**RE: Exempted development ED 420 granted for 14 The Drive, Ocean Links**

**Re:** Application for exemption in accordance with Section 5 of the Planning and Development Act 2000 (as amended) in respect of construction of an 18.5 sq m single storey extension to the rear of existing dwelling at 14 The Drive, Ocean Links, Strandhill, Co. Sligo.

1  
1:100  
Proposed Ground Floor Layout

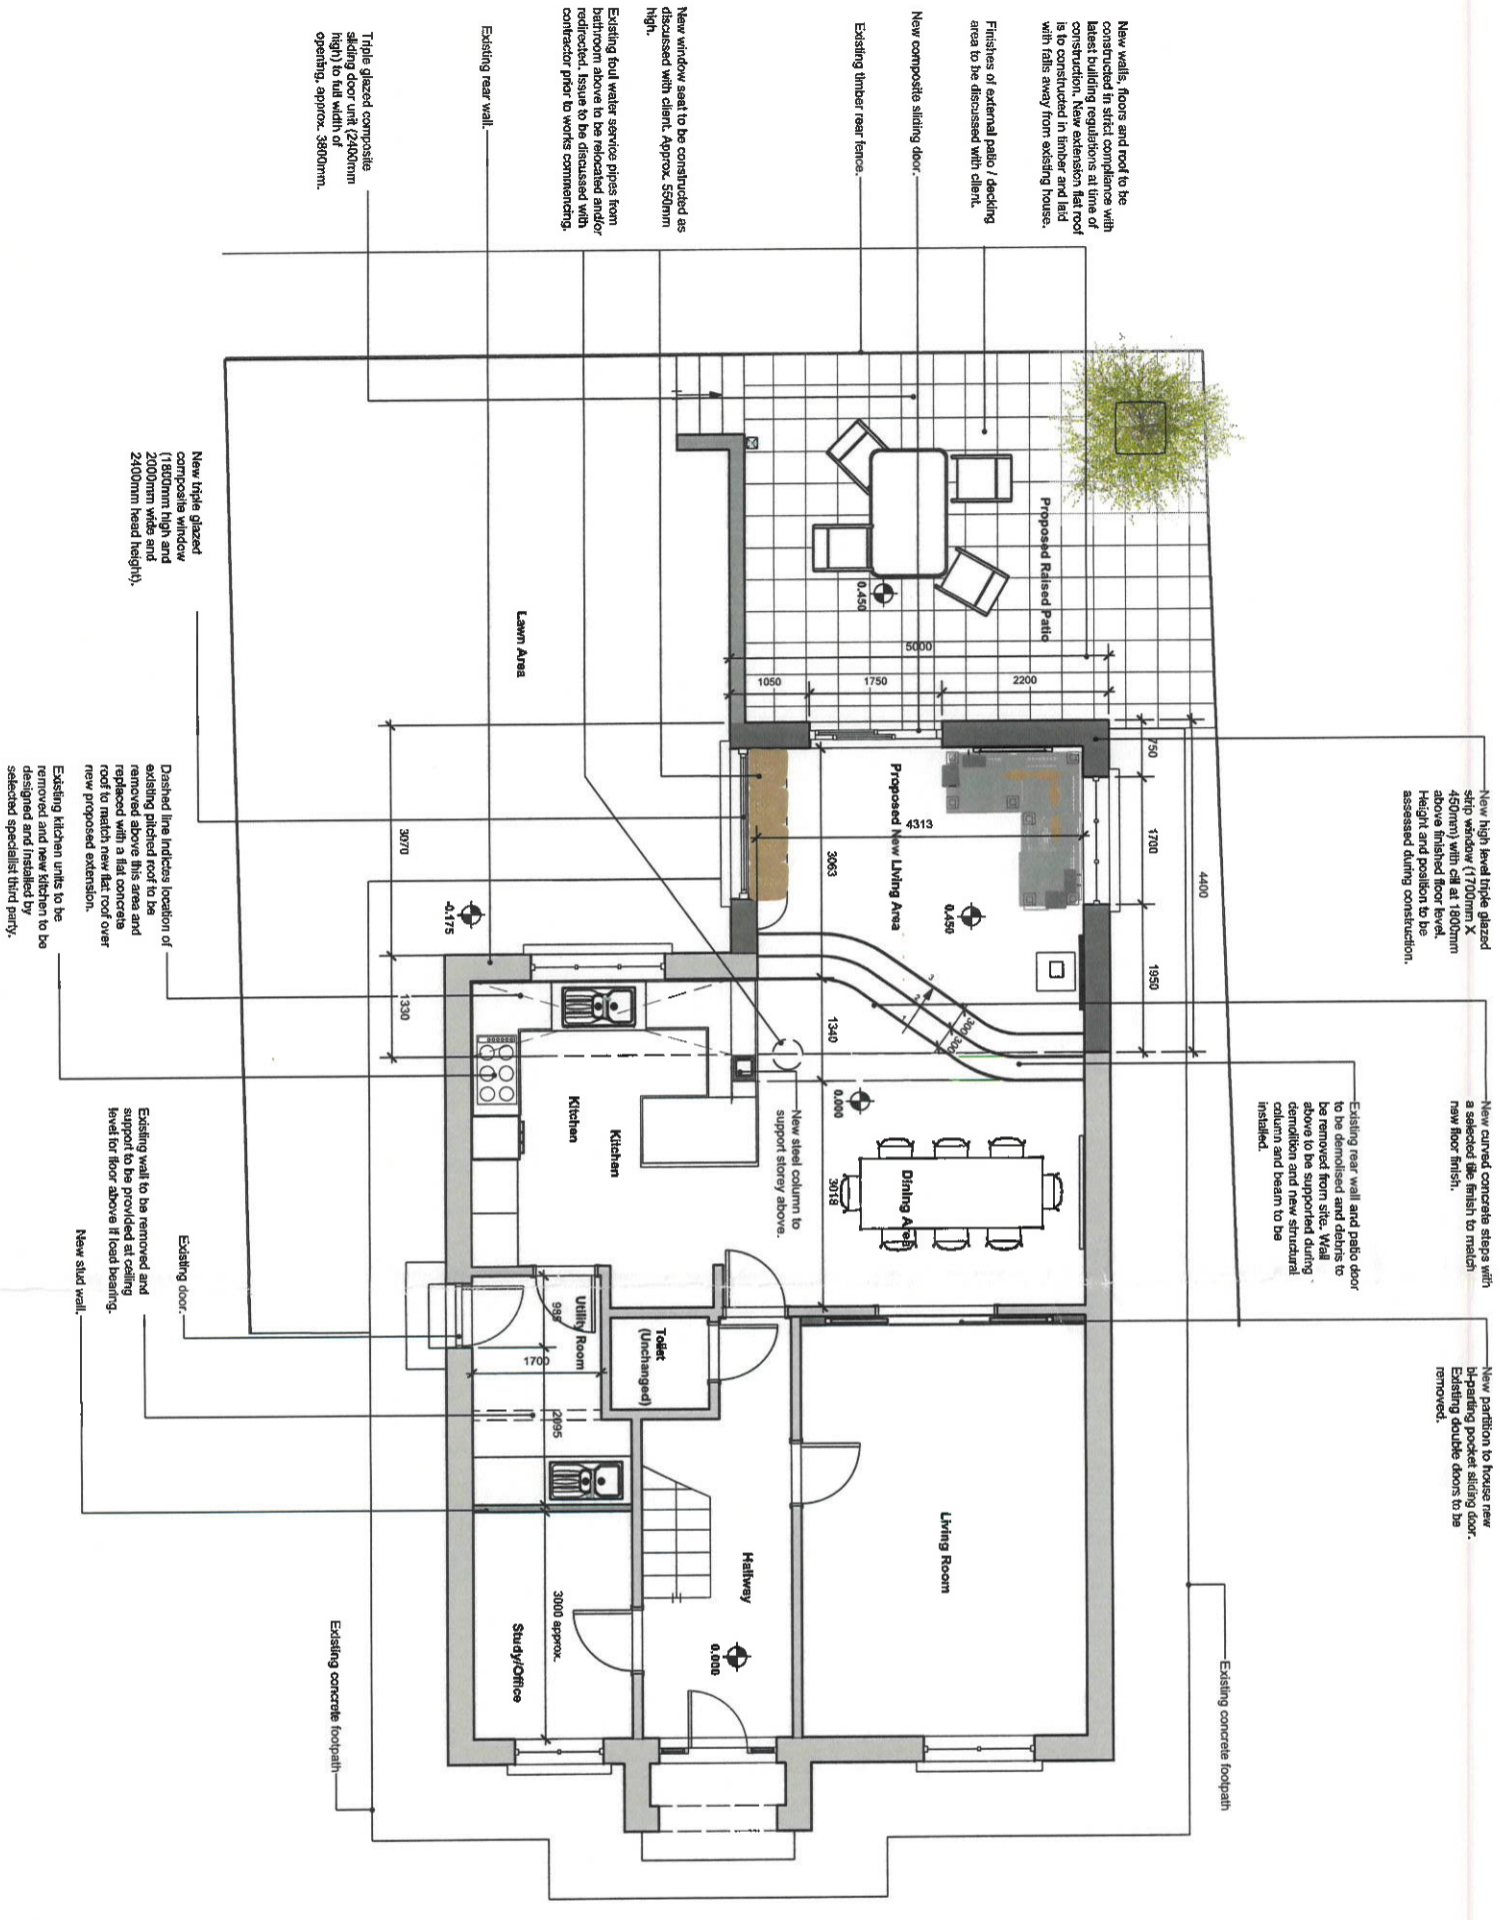
- Extension is stepping up 0.45m (c. 1.5 foot) to a floor which is 1.5 foot higher than ground floor. This per my interpretation is stepping onto a different floor. Per Government planning guidelines, once you go above a single storey which I deem this to be, you need to be 2m (6.6ft) from your neighbour boundary and there is only 5.6ft from our boundary fence. Per our neighbours plans there is also a window which will be on the side facing our garden.
- The extension will lead to a loss of light and overshadowing in our garden and will feel oppressive and overbearing for us as neighbours.
- The extension is not in keeping with the estate. It is a very bulky flat roof extension and does not fit into the landscape in Strandhill which is a place of natural beauty with the sea one side and Knockarea Mountain the other side.

- 1) **Height of the extension** – The proposed 1.5 storey flat roof extension as advised by Leonora McConville height to be c. 3.7m (12 foot). This is c. 3 – 4 inches from cill level of top window. This is materially different to drawings given to Sligo Coco which to the normal eye looks c. 1.5 foot from top cill level.  
The neighbours are raising their floor by 0.45m (1.5 foot) and as discussed with Frank Moylan, I deem this to be another floor which is where interpretation of 1.5 storey extension comes from.  
Per government planning website, once you go above one storey, required to be 2m (c. 6.6 foot) from boundary and there is only 5.6ft (less than 2m) from boundary fence.
